Ribble Valley Borough Council

App no: 3.2026.0287

Address: Unit 12 Twin Brook Business Park Twin Brook Road Clitheroe

Proposal: Proposed extension to existing light industrial unit together with additional off street parking area.

**2 Site Plan**  
1 : 500

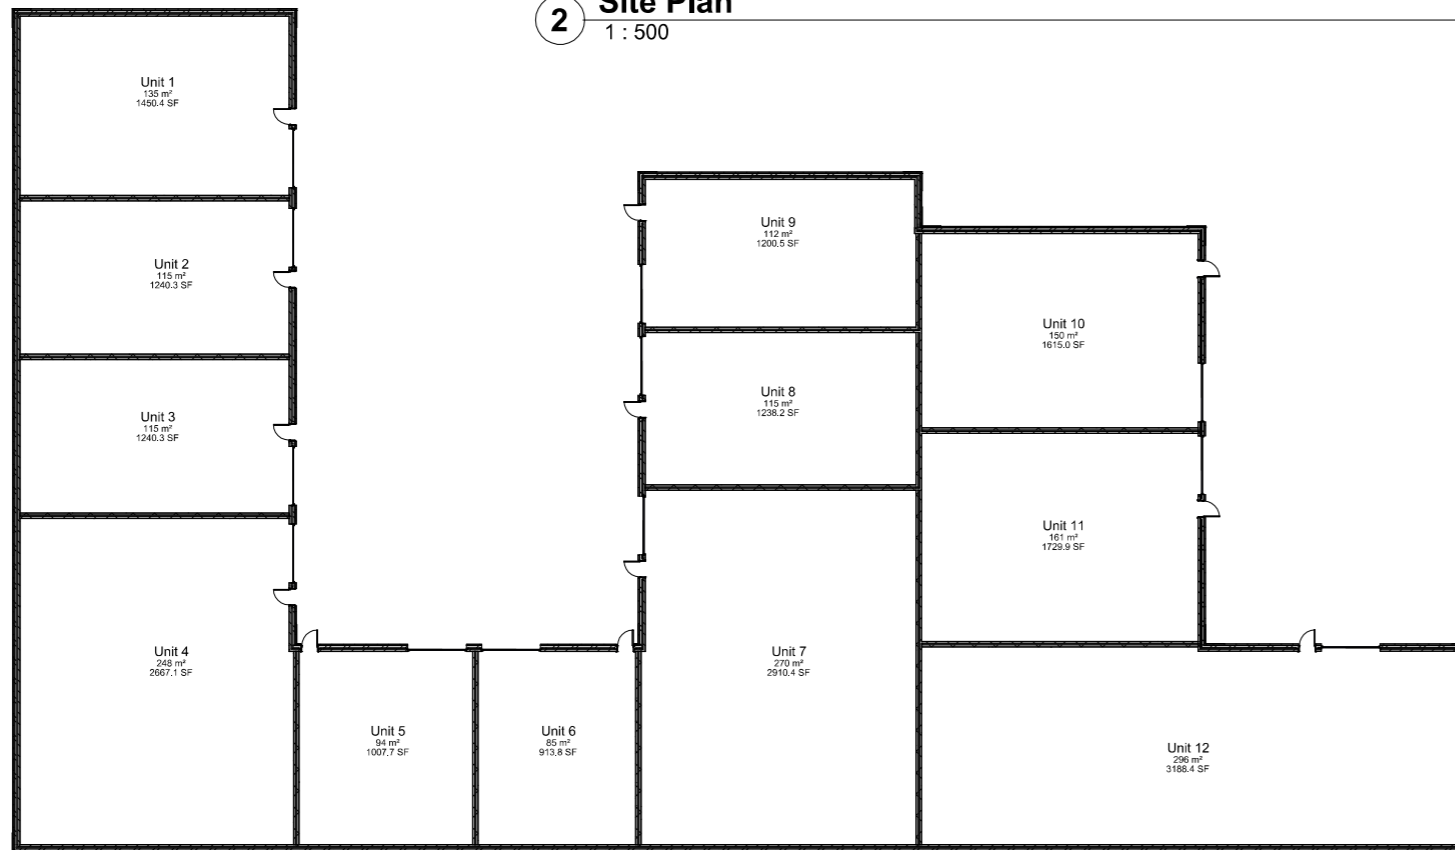
The existing plans show the tracking for a 11/12m rigid HGV. The proposed extension will result in a loss of yard space which allows this manoeuvre to be undertaken. A tracking drawing is requested to show the alternative arrangements for the longest HGV's accessing units 10, 11 and 12.

The bike lockers shown on existing plans are lost from scheme and these should be included in the proposal for at least 2 bicycles.

5 Proposed Site Plan  
1 : 500

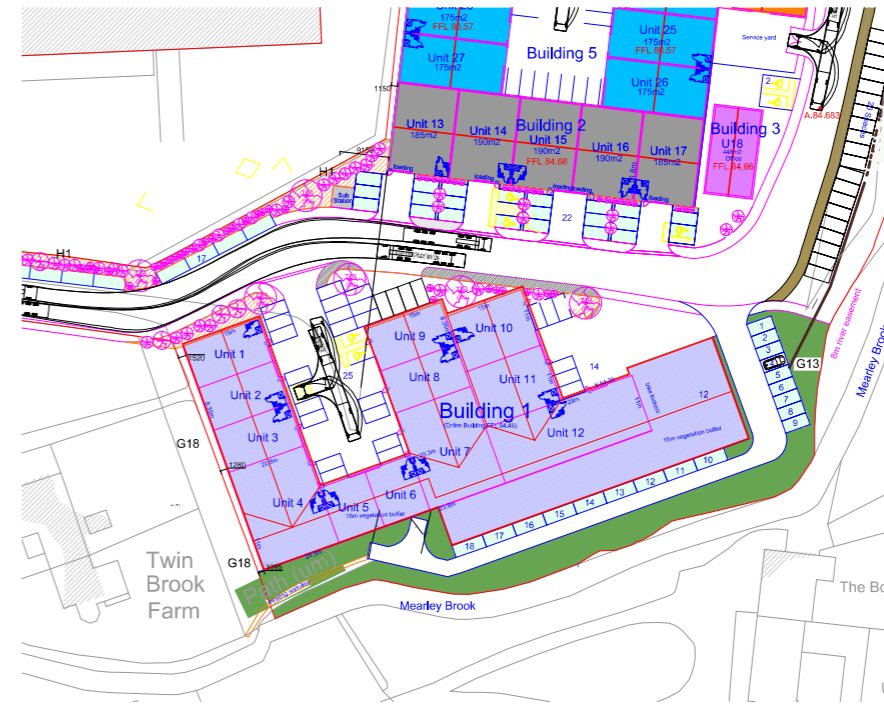
Twin Brook Road is privately maintained. The existing access on Twin Brook Road is proposed to be widened by approximately 7m to the east side. Changes to the access road will need to be agreed with the landowner if that is not the applicant.

There are currently 26 spaces provided for units 10, 11 and 12. The proposed layout amends the current layout. It is noted that a row of 6 spaces is doubled up to 12 which makes them impractical for a shared use.

There are proposed layout reduces the existing provision to 24 and comprises of 18 car parking spaces for unit 12, 3 spaces for unit 10 and 3 spaces for unit 11. It is noted that none of these spaces are doubled up making them all useable.

Unit 12 would require 20 spaces which is a shortfall of 2 spaces.

Public footpath FP0301006a runs to the rear of the building and the proposed rear extension and associated car parking appears to obstruct the line of the path. We would request that the site plan is overlaid onto the public footpath route to highlight this clearly or otherwise.

The footpath needs to be provided on the exact route on a minimum 2m wide path. If the intention is to formally apply to divert the line of the path, then we would request details of the diversion route, surface and boundary treatment is submitted prior to the decision so we can give through advice.

Subject to secure and covered cycle parking for at least 2 bicycles being provided there is no objection to the overall parking provision and changes.

Lancashire County Council acting as the Highway Authority requests a swept path analysis for a 12m long rigid HGV or the longest vehicle which accesses the site for units 10, 11 and 12.

We request a drawing is submitted to clearly show the line of FP0301006a and any proposals to divert the official line including a minimum width of 2m with surface and boundary proposals.
